A46 Newark Bypass

Scheme Number: TR010065

The A46 Newark Bypass
Development Consent Order 202[x]

Comments on submissions received at the previous deadline

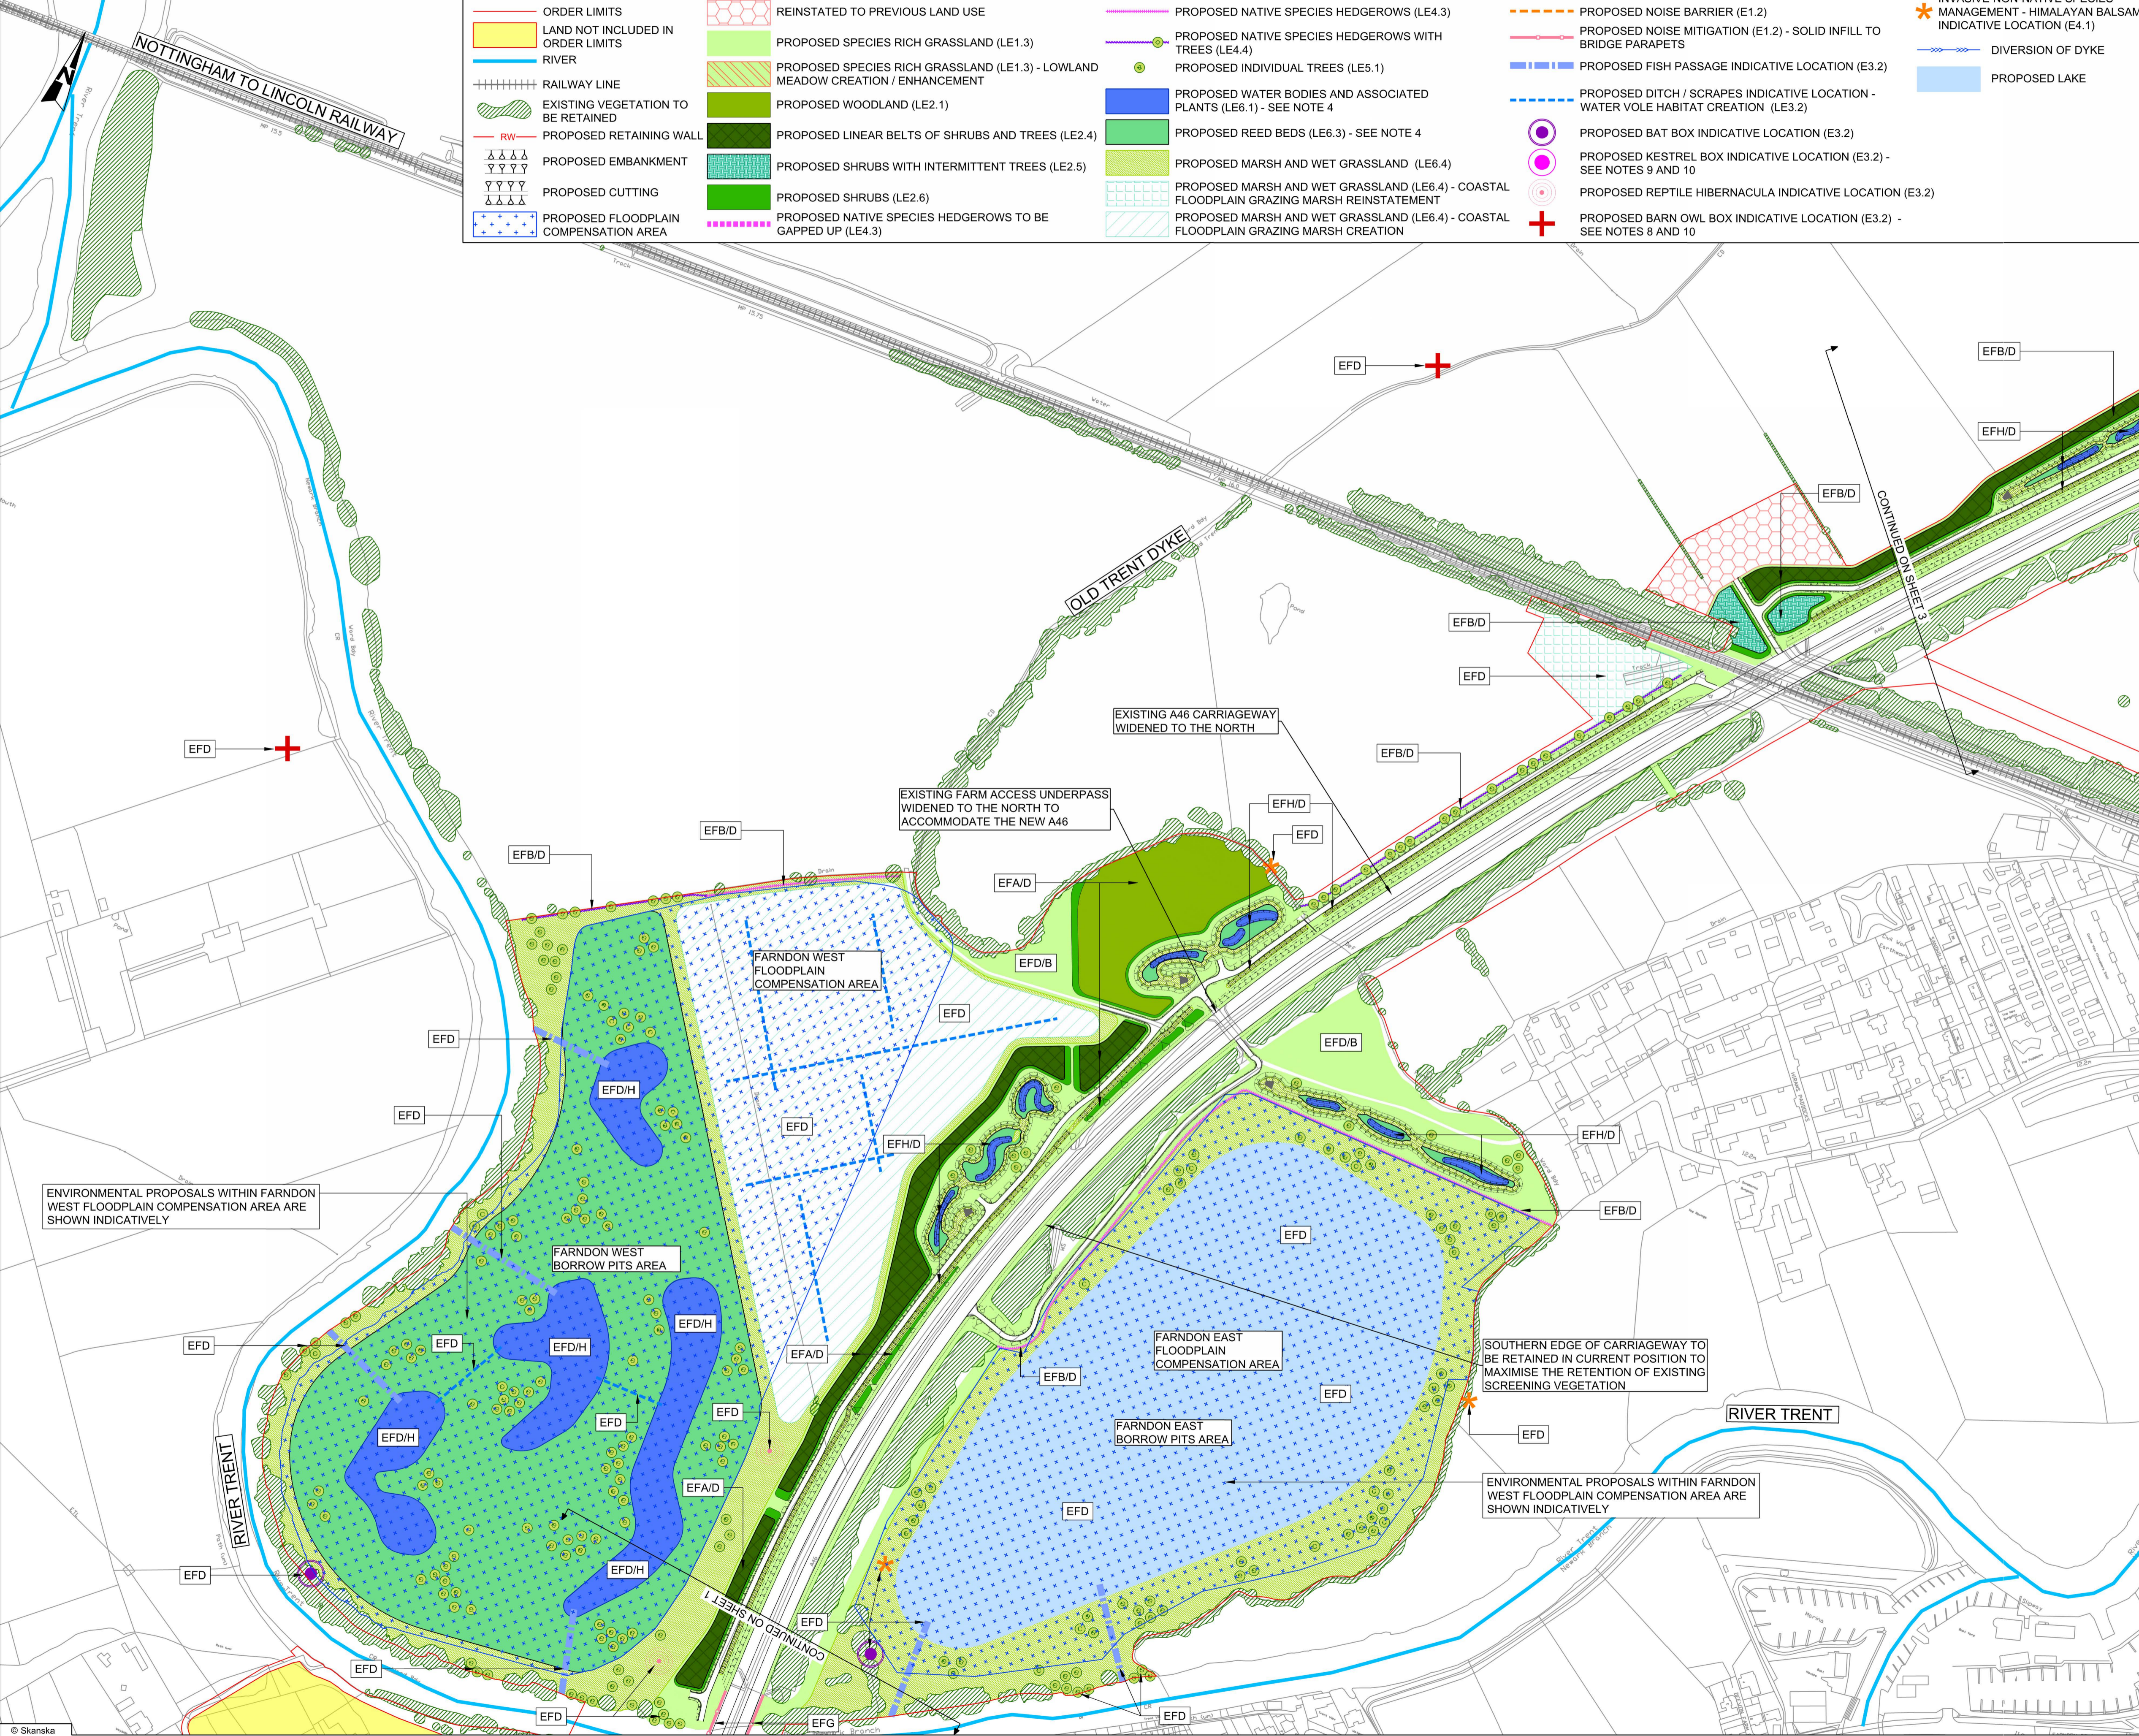
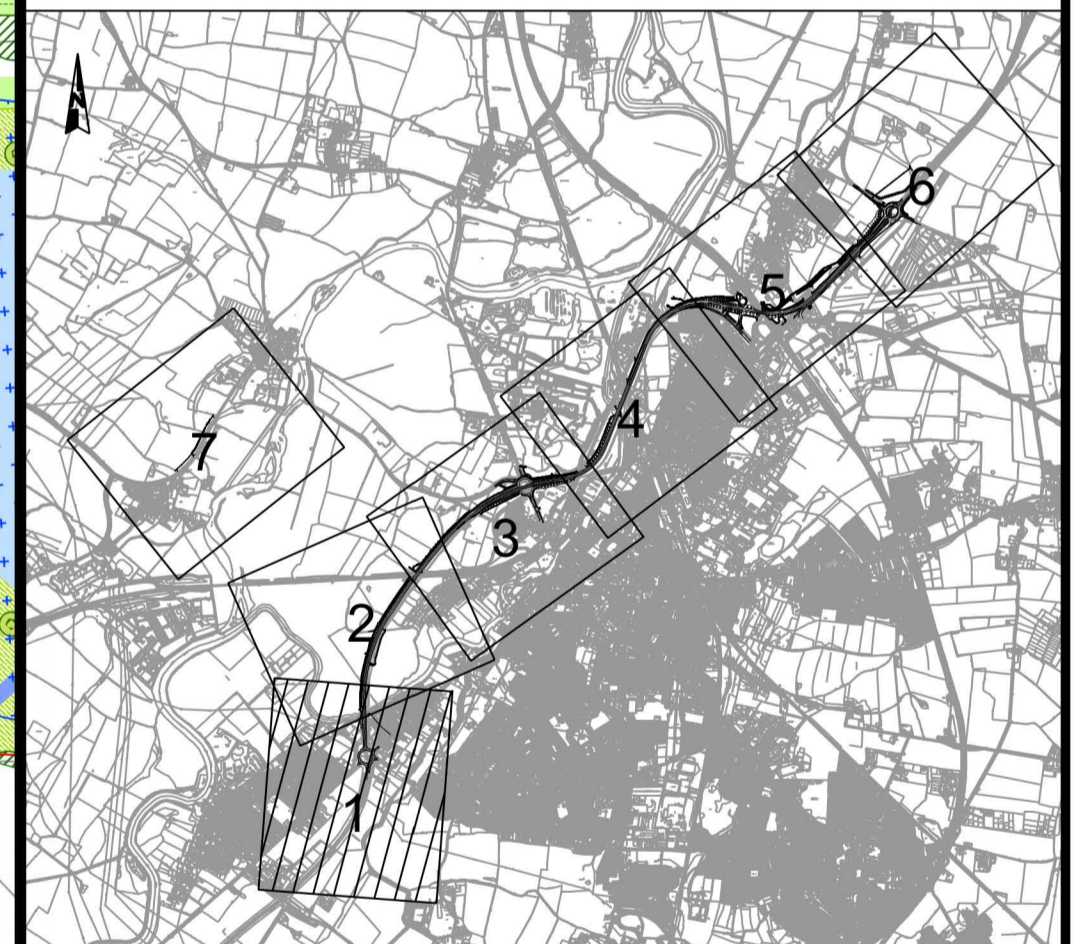
David Corden Response	The Applicant Response
<p>Hi. I live on [REDACTED] a quarter of a mile from the Farndon Island, and I would like to make an observation about the proposed Farndon Island works. Having read your documentation I am aware that there will be a traffic light system and that the island will be widened, all of which I am in support of. However, I don't believe that the document details (to date) properly address the road noise to neighbouring streets. I would like to recommend that,</p> <ol style="list-style-type: none">1) noise cancelling road surfaces are used,2) some form of (cosmetically appealing) noise deflection barriers are used on the southerly approach to the Farndon Island and for the island itself to deflect noise (effectively from the River Devon to the island,3) that such an approach include raised earth embankments.4) There is also an abundance of land around this island approach which could be planted with trees, to further aid noise reduction. This could include tree lining the Farndon Road itself, from the island. This would make this popular approach to Newark more visually appealing.5) If the speed of approaching traffic to the island could be mitigated then that may also assist, however, I suspect that the new traffic lights may solve this problem. Thank you for your consideration, and for making the noise associated with this road / island less of a nuisance for residents.	<p>The Applicant has assessed the impacts associated with the Scheme and, where required, mitigation has been provided. As a publicly funded scheme the Applicant is not able to undertake works that are not required as a direct impact of the Scheme. Scheme proposals including essential mitigation are therefore restricted to the Order Limits, which have been established as a result of the design development and environmental assessment work. The Scheme Order Limits are shown on Figure 1.1 (Scheme Draft Order Limits) of the Environmental Statement Figures [AS-023].</p> <p>The Applicant confirms suitable noise mitigation measures considering potential physical constraints will be provided along the Scheme which will include standard height parapets with infill panels along the west side of the proposed Windmill viaduct and the east side of the existing Windmill viaduct. It is noted that the parapet along the western side of the viaduct will extend further south towards Farndon Roundabout, transitioning in form into a 2 metre noise barrier. No further noise screening is proposed in the southern approach to Farndon Roundabout to address operational noise as the associated assessment in Chapter 11 (Noise and Vibration) of the Environmental Statement [APP-055] did not identify noise impacts with the potential to lead to a significant effect.</p> <p>The Applicant has also addressed each of the five listed points raised in the Interested Party's submission:</p> <ol style="list-style-type: none">1) Low-noise road surfacing will be provided throughout the Scheme. Low noise road surfacing is already present on the northbound approach to Farndon Roundabout and around the roundabout itself.2) The landscape and visual impact assessment of the Scheme (documented in Chapter 7 (Landscape and Visual Effects) of the Environmental Statement [APP-051]) did not identify any mitigation works required adjacent to the existing northbound approach to Farndon Roundabout and all existing vegetation is retained. Details of this mitigation can be seen in Sheet 1 of Figure 2.3 (Environmental Masterplan) of the Environmental Statement Figures [AS-026]. <p>Extract from Sheet 1 of Figure 2.3:</p>

<p>Operational noise impacts of the Scheme are adverse in some areas and beneficial in others but none of these are anticipated to be significant with the proposed mitigation in place; the assessment for noise is documented in Chapter 11 (Noise and Vibration) of the Environmental Statement [APP-055]. Sheet 7 of Figure 11.9 (Short-term Noise Change) [AS-063] and Figure 11.10 (Long-term Noise Change) of the Environmental Statement Figures [AS-064] show that the impact in the short-term and long-term respectively in the Farndon area is predominantly negligible or minor, depending upon the exact location in relation to the Scheme. It is therefore not possible to justify the installation of additional noise barriers as suggested.</p> <p>Requirement 16 of the draft Development Consent Order [APP-021] secures the provision of the noise mitigation measures presented within Chapter 11 (Noise and Vibration) of the Environmental Statement [APP-055] which includes the measures shown on Figure 2.3 Environmental Masterplan of the Environmental Statement Figures [AS-026].</p> <ol style="list-style-type: none">3) Similarly, the outputs of assessments documented in Chapter 11 (Noise and Vibration) of the Environmental Statement [APP-055] and Chapter 7 (Landscape and Visual Effects) of the Environmental Statement [APP-051] have not resulted in the need to propose raised earth embankments along the approaches to Farndon Roundabout. It is therefore not possible to justify the installation of additional raised earth embankments as suggested.4) Given the limited change in visual amenity arising from the roundabout itself, new swathes of planting are not considered as being required from the perspective of essential mitigation. However, existing vegetation would be retained on the approach to Farndon Roundabout, with a small area of new replacement planting proposed to the north western extents when exiting the roundabout heading north on the A46.5) The Permanent Speed Limit Plans [AS-014] show a 40mph limit on the approach Farndon roundabout which will reduce speeds on the approach to the roundabout.
